Application by North Somerset District Council for Portishead Branch Line – MetroWest Phase 1
The Examining Authority’s Further written questions and requests for information (ExQ2)
Issued on 26 January 2021

ExQ2: [26 January 2021]**Responses due by Deadline 5: Tuesday 16 February 2021**

2.38 - Portishead Station Car Park Layout, Landscaping and New Boulevard and Access Plan

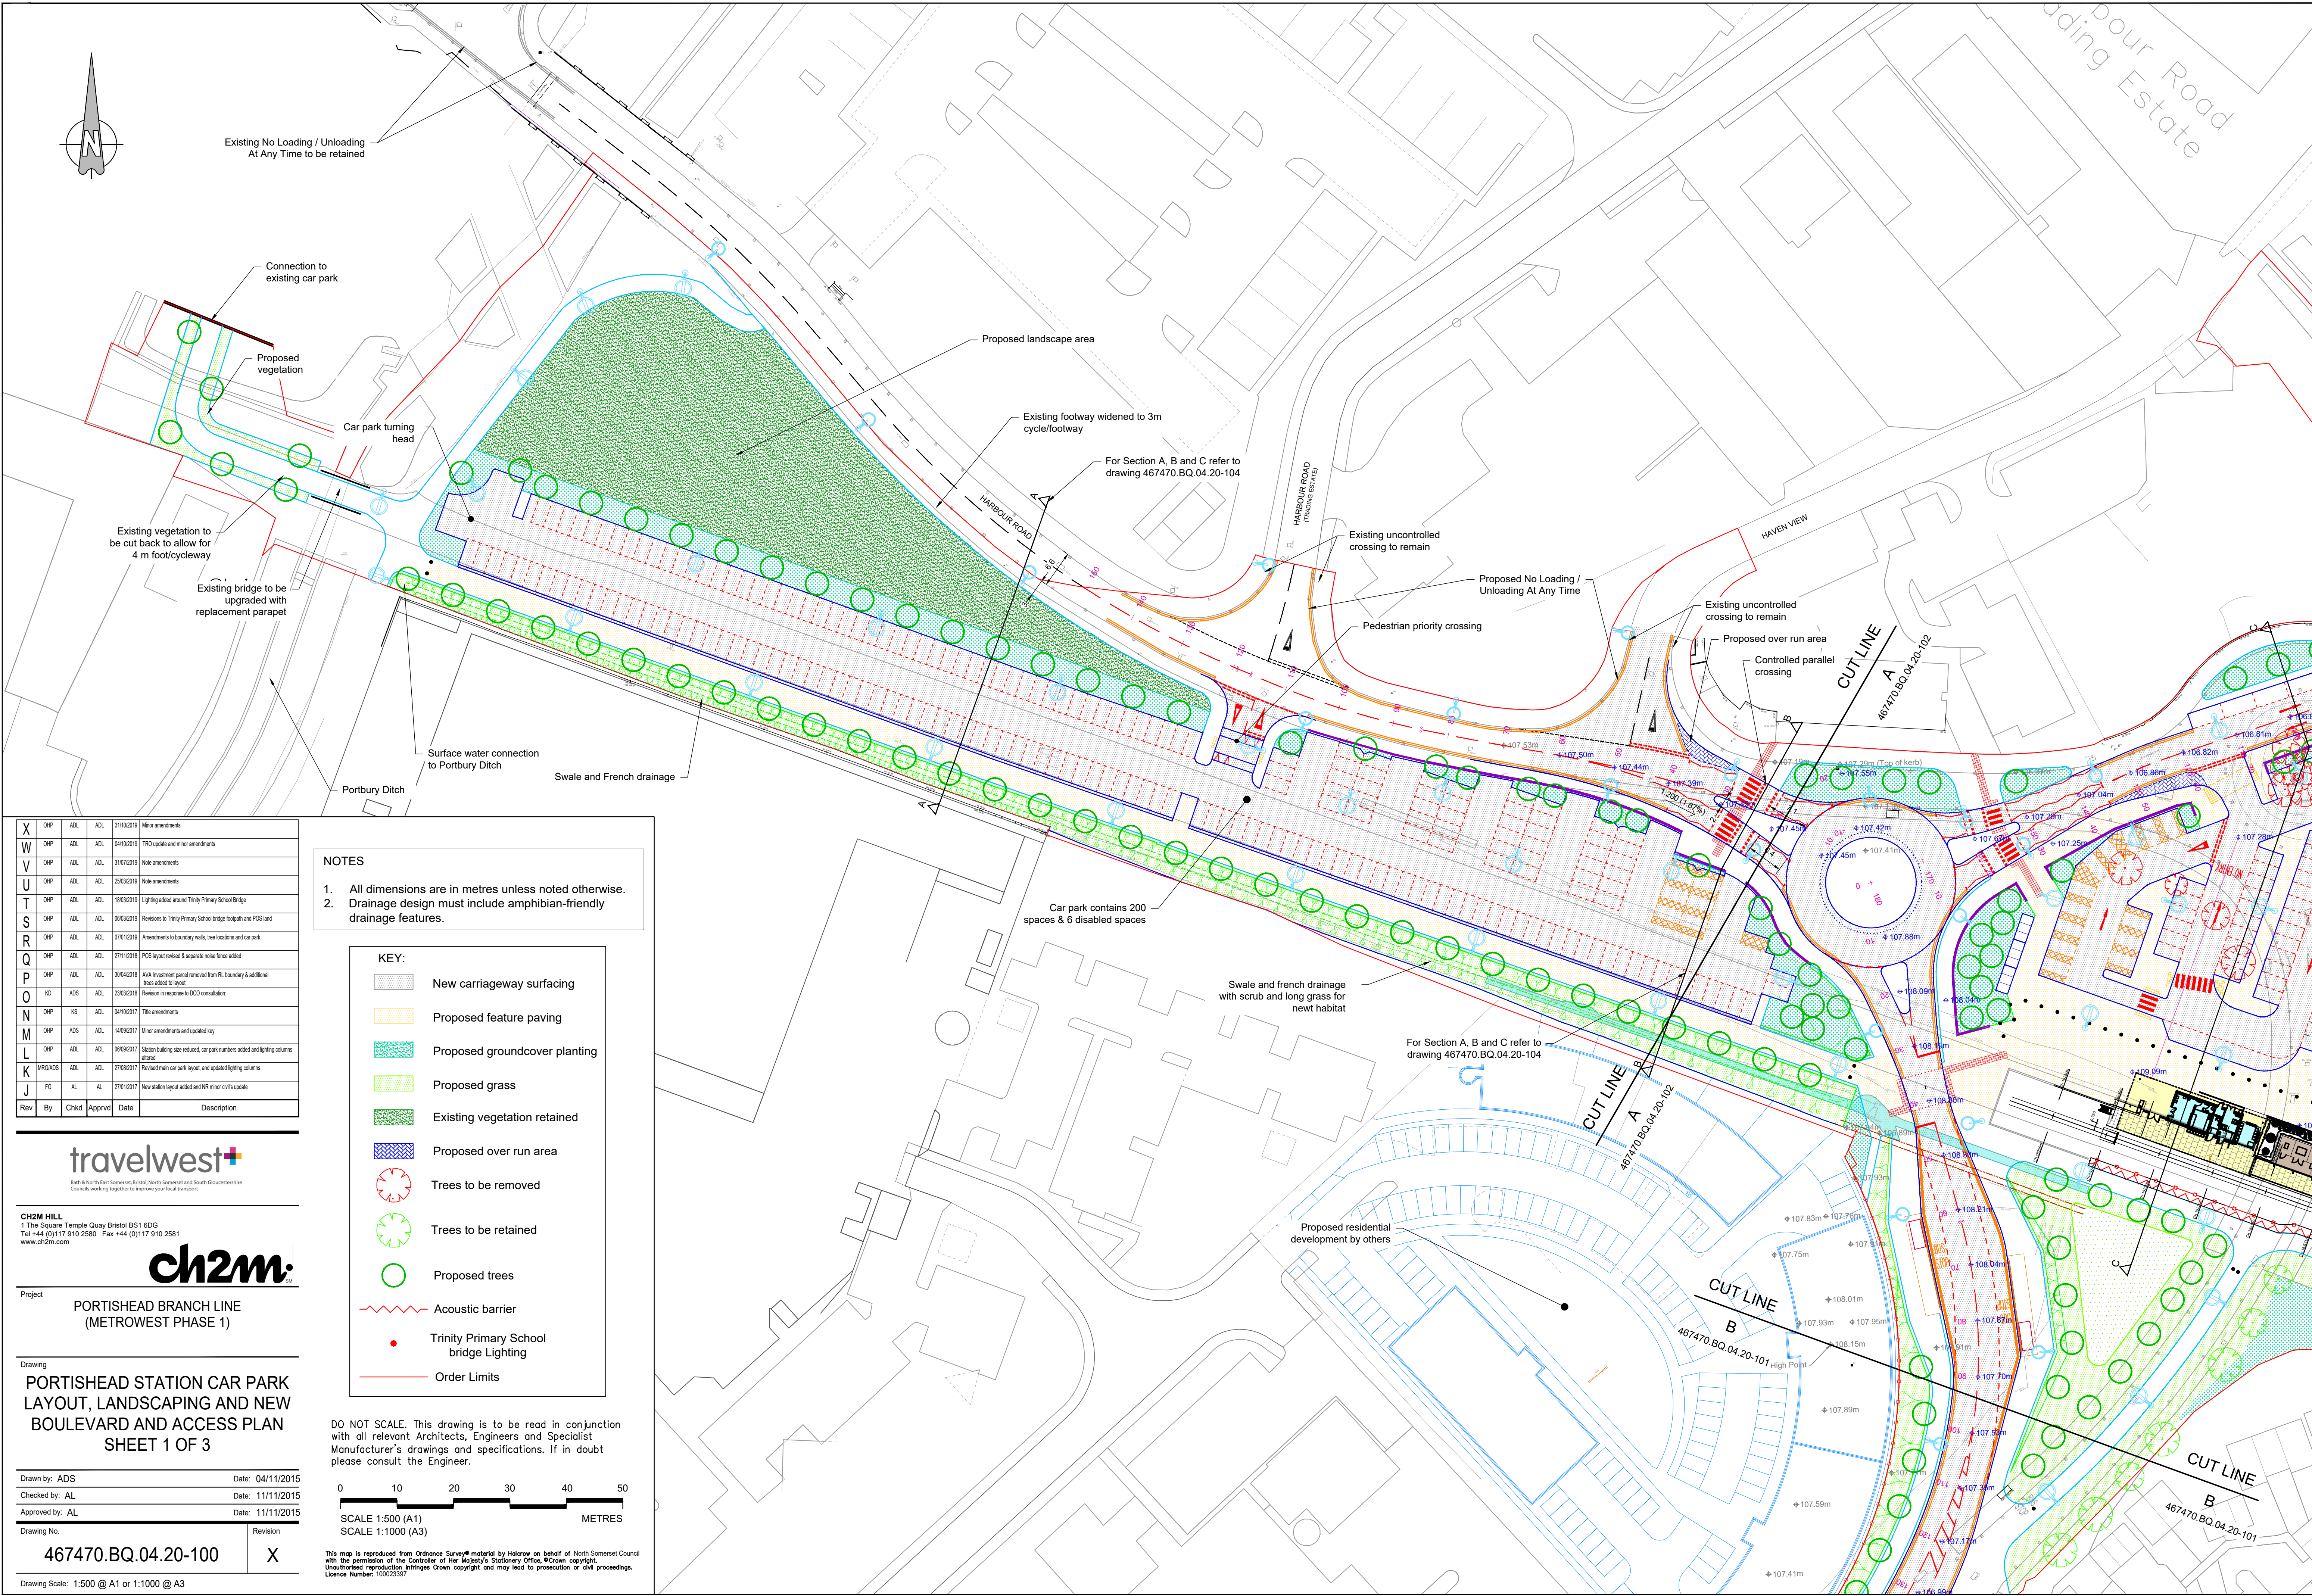
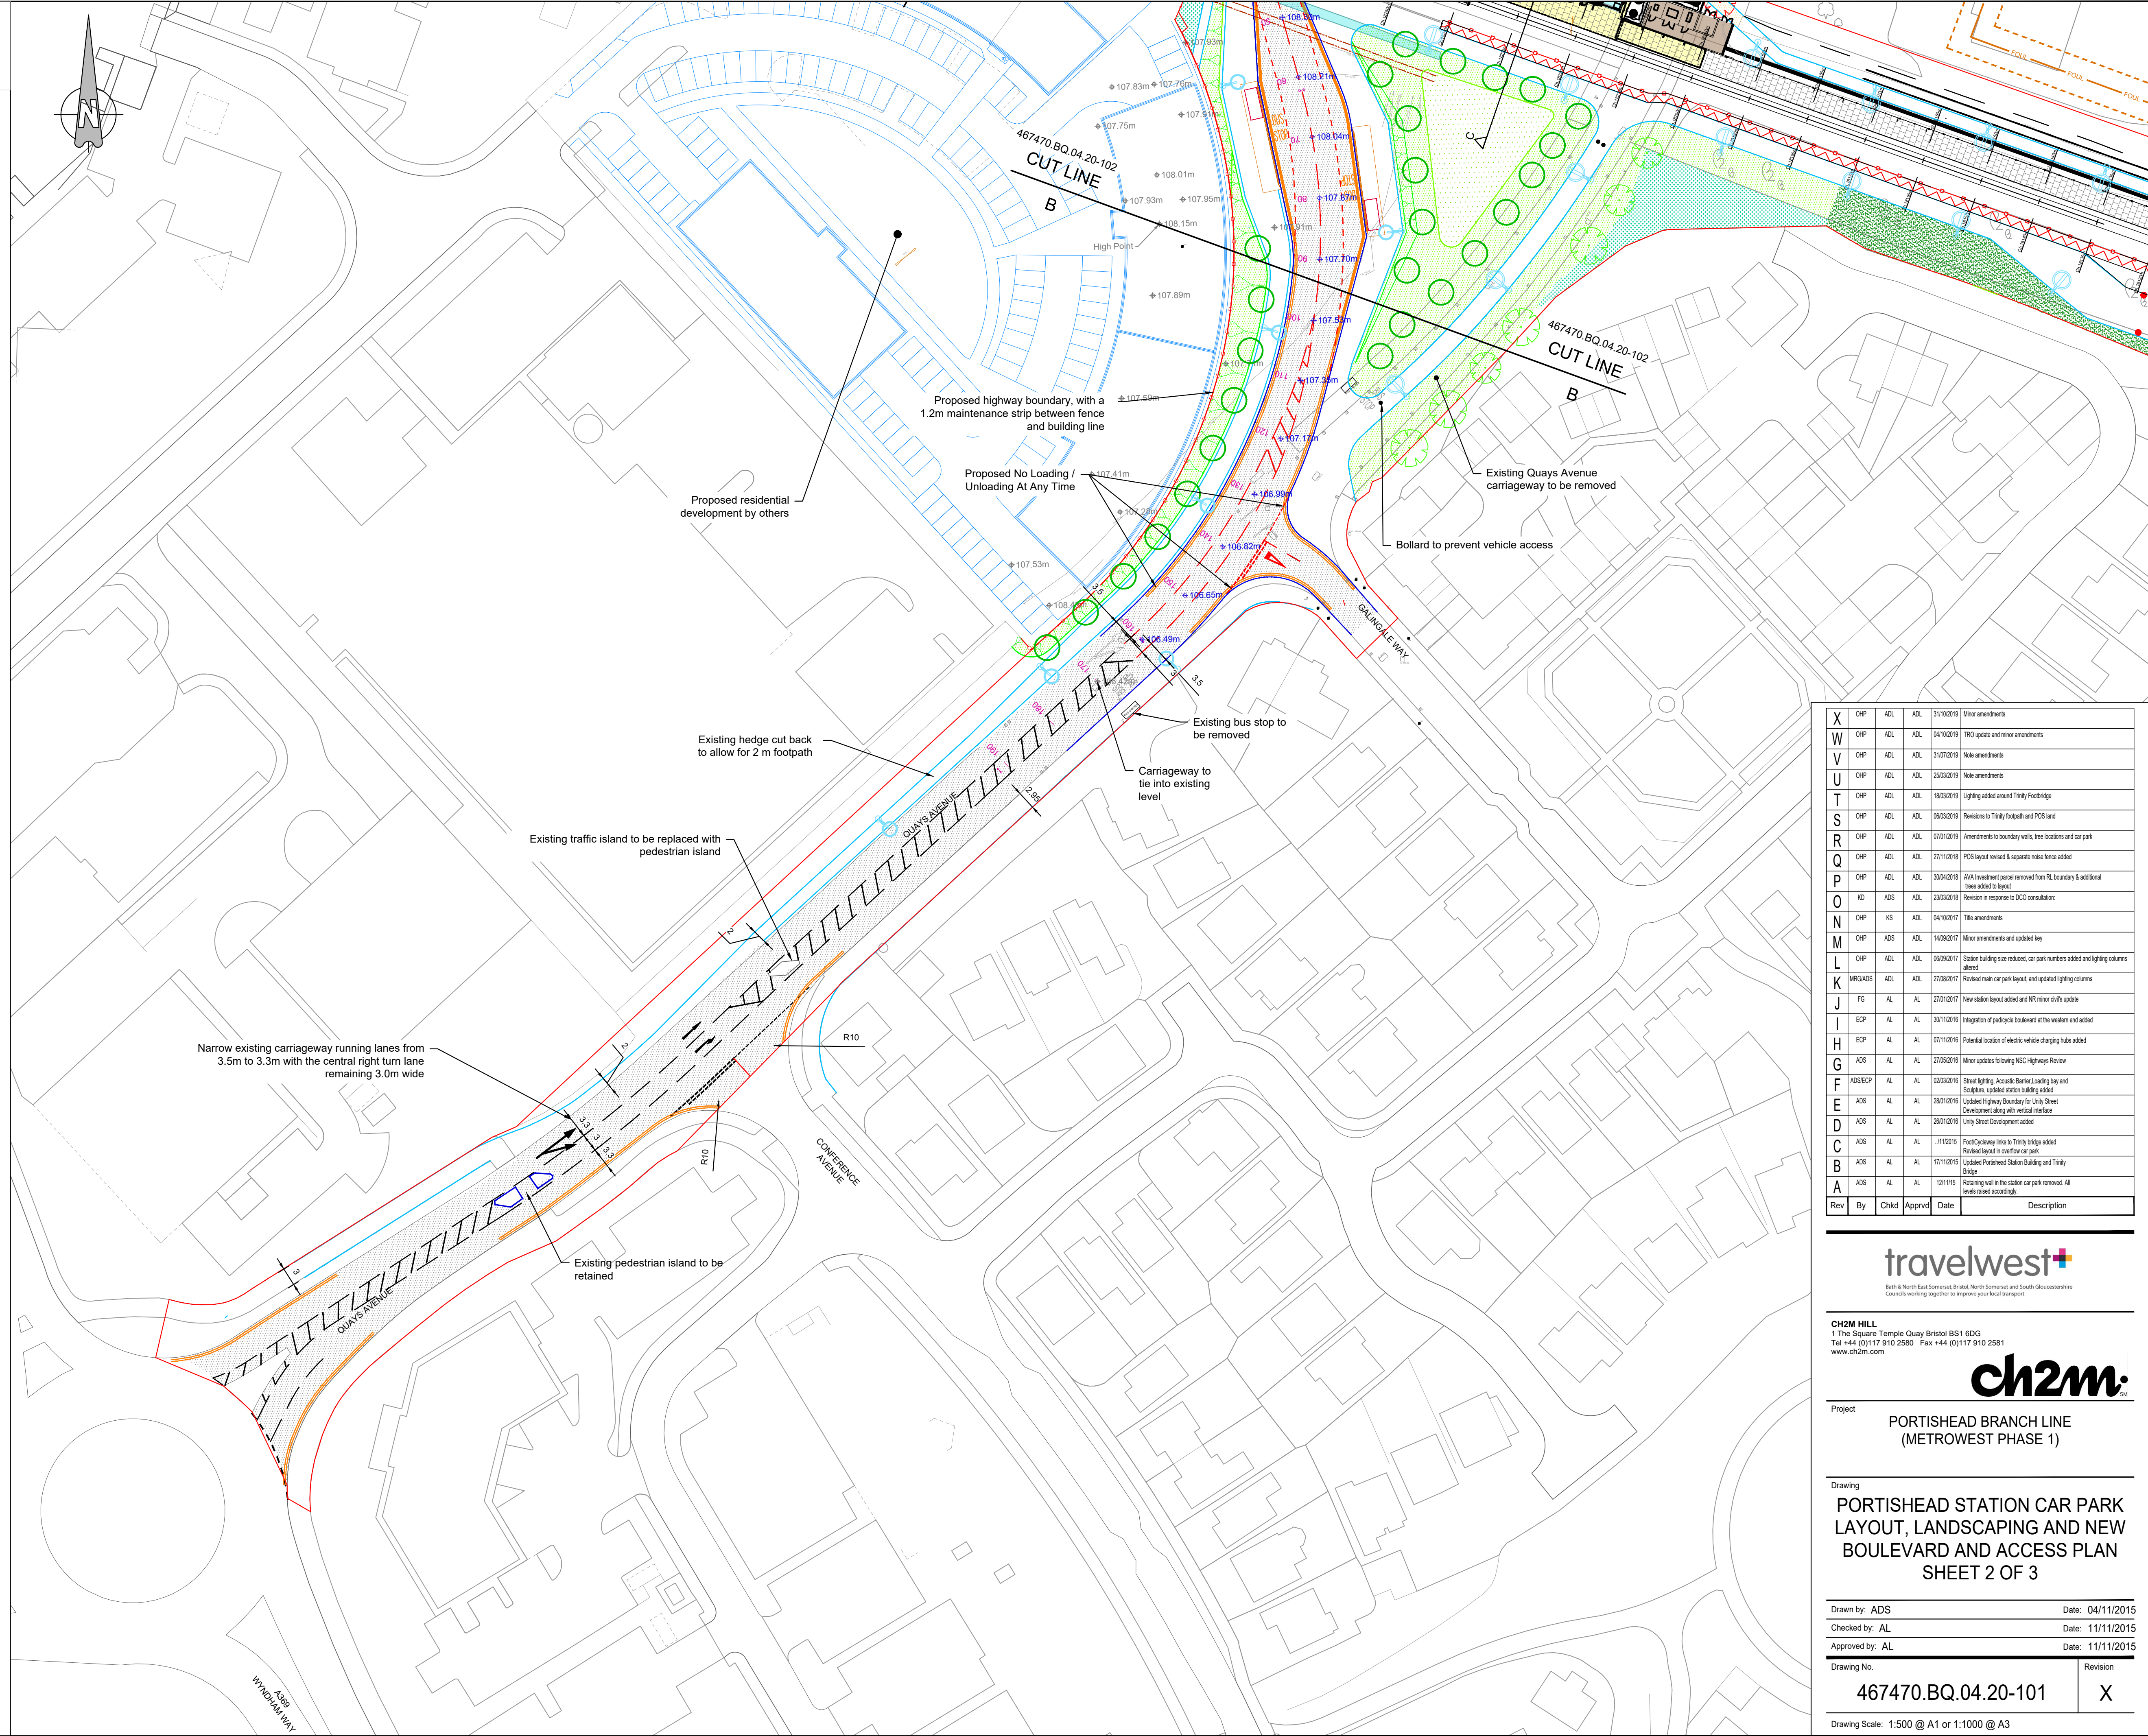
CA .2.1	<i>Crown Land</i> The Applicant	Provide an update on the progress made regarding obtaining Crown consent and whether this is likely to be achieved before the close of the Examination.
DE Design		
DE .2.1	<i>Work No 5</i> <i>Portishead Station</i> The Applicant	ExQ1 answer DE.1.5 [REP2-013] states that the GSM-R mast antenna cannot be attached to the station building for maintenance and safety reasons. If proposed as a separate structure, how would its visual impact be minimised?
DE .2.2	<i>Work no 5</i> <i>Portishead Station</i>	Harbour Residential Care Centre which faces the Quays Avenue/ Harbour Road roundabout is not currently shown on the existing or proposed plans, in particular Portishead Station car park layout, landscaping and new boulevard and access plans 467470.BQ.04.20-100 & 102 Rev X. In order to

ExQ2	Question to:	Question
	The Applicant	enable an accurate assessment of its relationship to the proposed station can the Applicant provide revised layout plans to include the care home building.
DE .2.3	<i>Work no 5 Portishead Station</i> The Applicant	The Applicant [REP4-021] and NSDC [REP4-042] have indicated that the most appropriate energy efficiency/ micro generation measures would be to install solar panels on the roof of the station building. The Applicant states that they will discuss the potential for such provision with the relevant planning authority, Network Rail and the Train Operating Company. Provide an update on such discussions, a drawing to indicate the location/ extent of such solar panels, and state how such measures can be specifically secured within the DCO – would an additional requirement necessary?
DE .2.4	<i>Work No 7 Trinity Footbridge</i> The Applicant	Provide a site location plan of the footbridge shown in the photographs at REP4-010.
